From: Laura Gibbons <Laura.Gibbons@arun.gov.uk>
Sent: 18 May 2021 08:58
To: Planning.Responses <Planning.Responses@arun.gov.uk>
Cc: Anita Gardner <Anita.Gardner@arun.gov.uk>
Subject: RE: Planning Consultation on: LU/111/21/DOC

Engineers Comments Regarding Condition 8

Application No: LU/111/21/DOC
Registered: 14th April 2021
Site Address: 46a & 47 Pier Road and Land North of Clifton Road Littlehampton BN17 5LW
Description of Works: Approval of details reserved by condition imposed under ref LU/287/17/PL relating to Condition Nos 7 - divert public sewers and 8 - foul & surface water sewerage disposal.

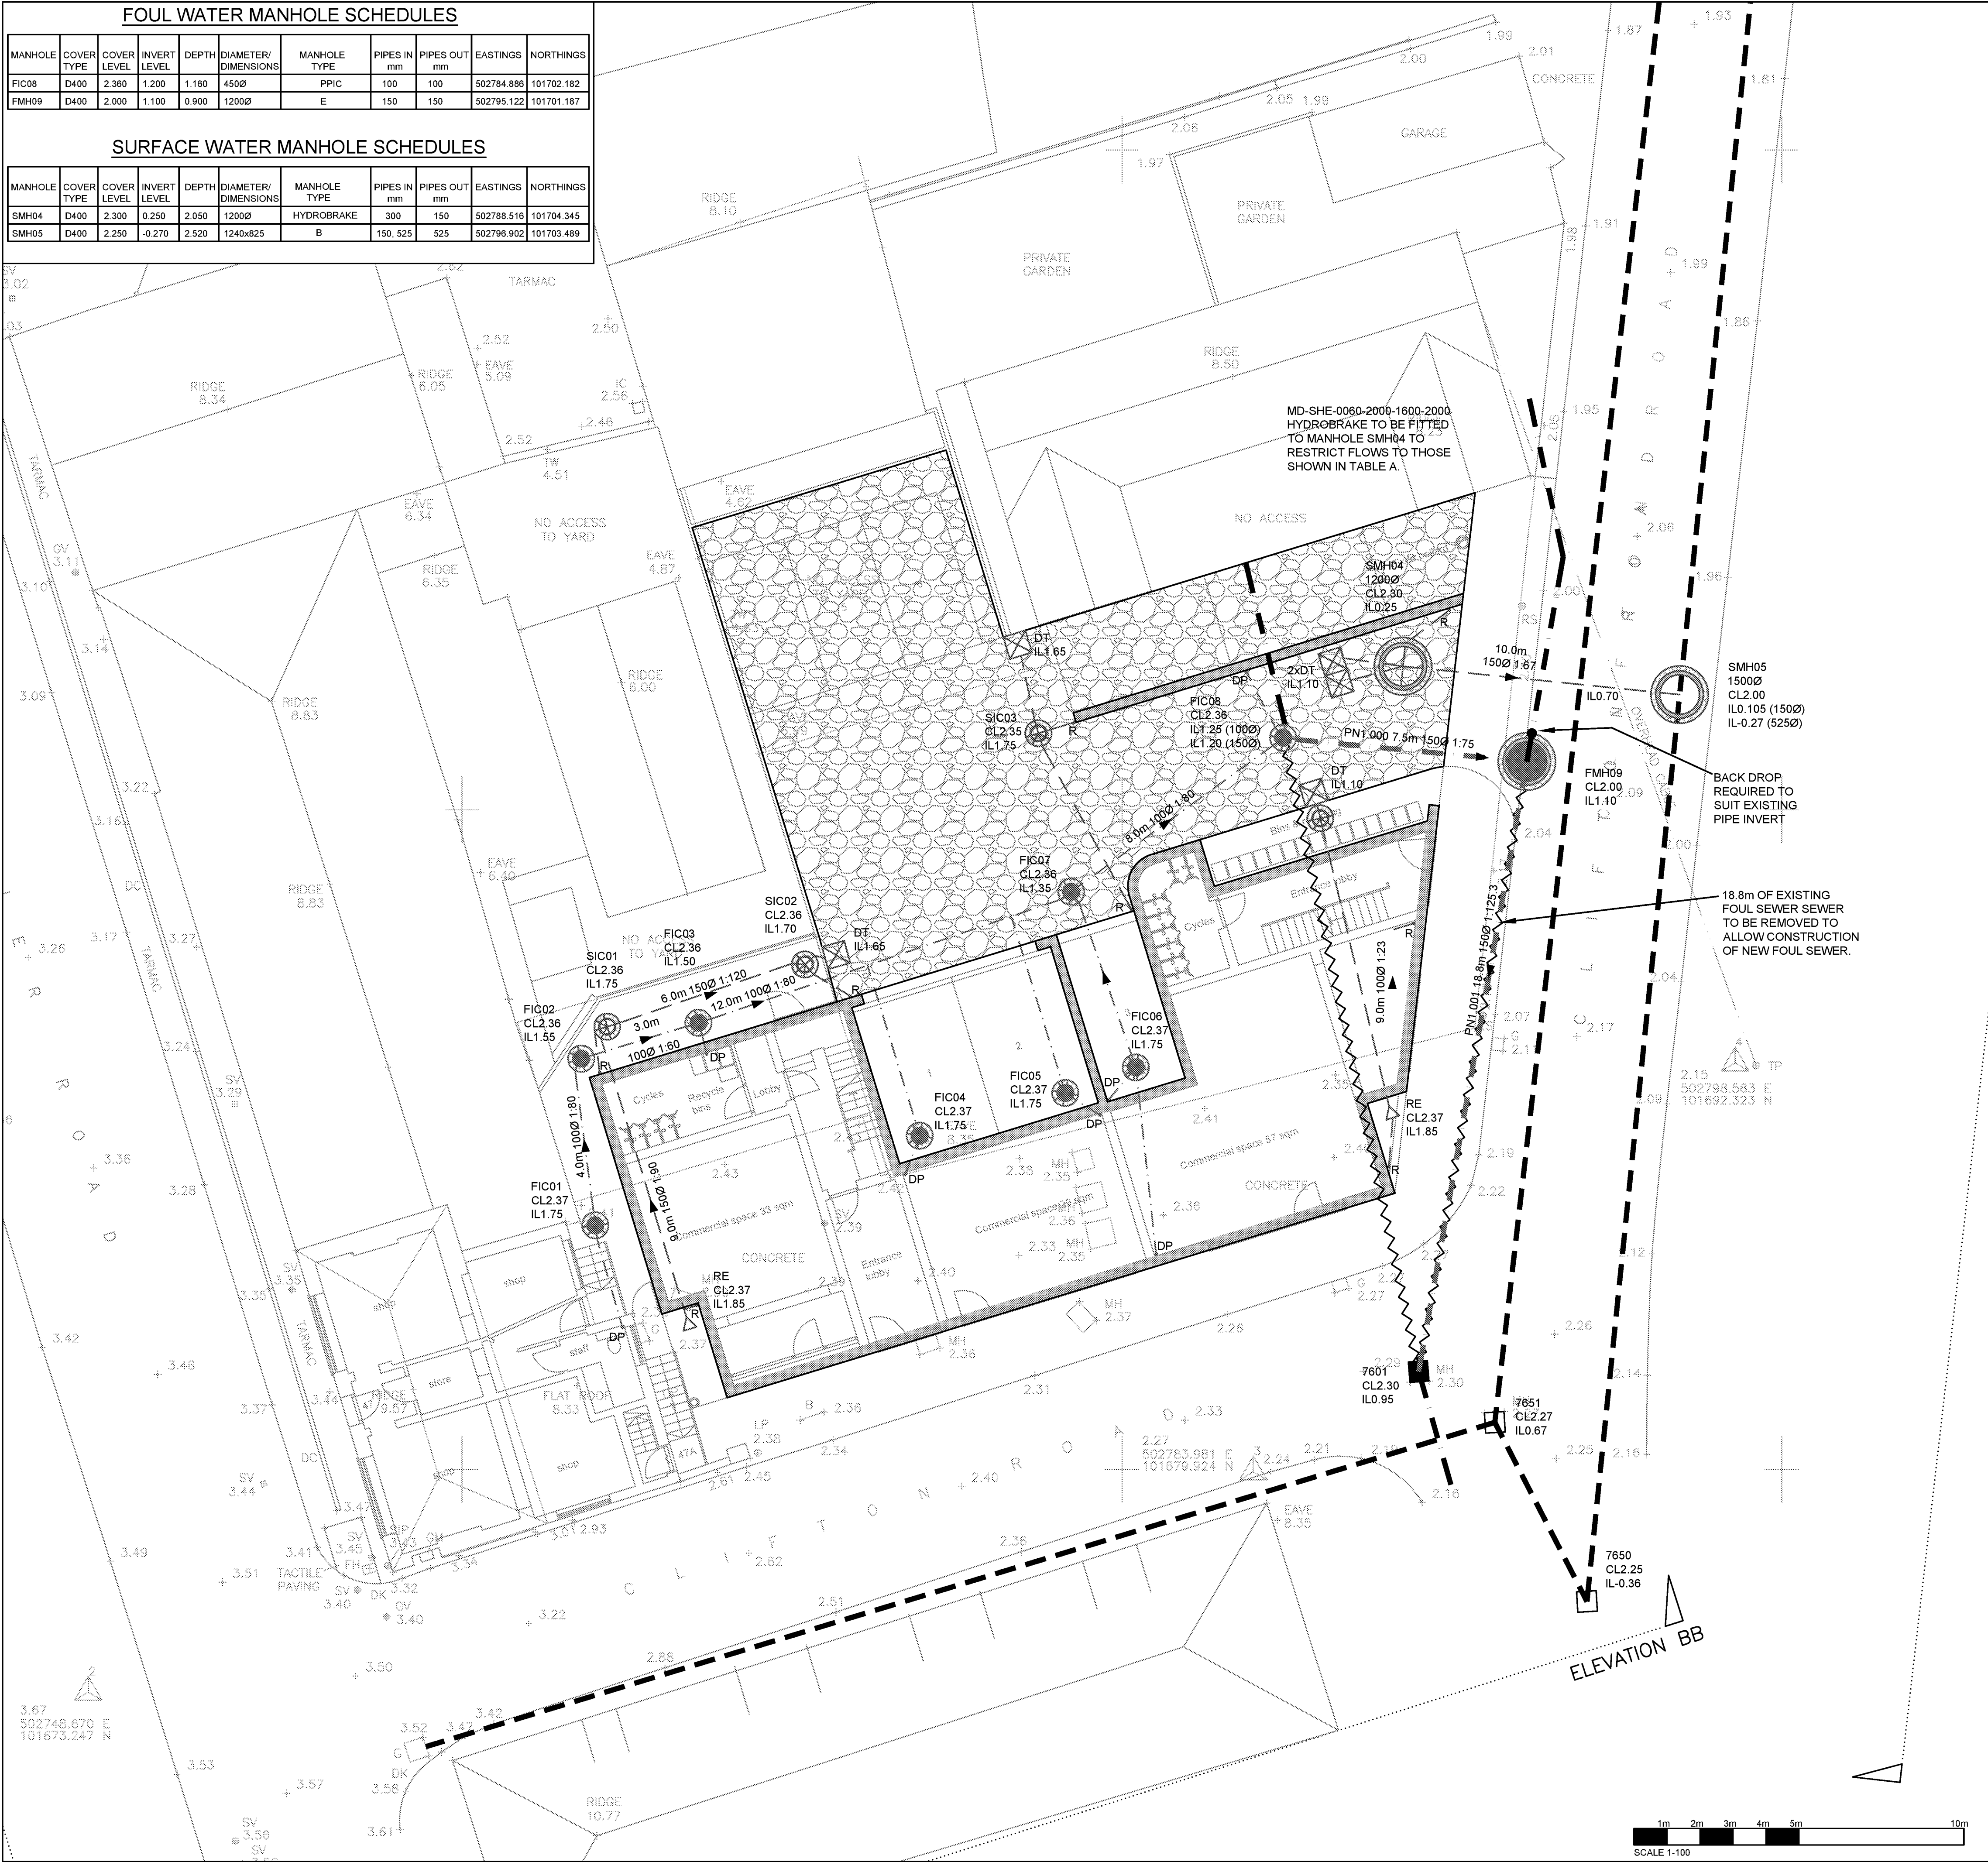
- Catchpits should be provided upstream of connections into permeable paving.
- Finish and formation levels of permeable paving should be noted on plan.
- Construction detail drawings should be supplied. Including a construction detail of the permeable paving.
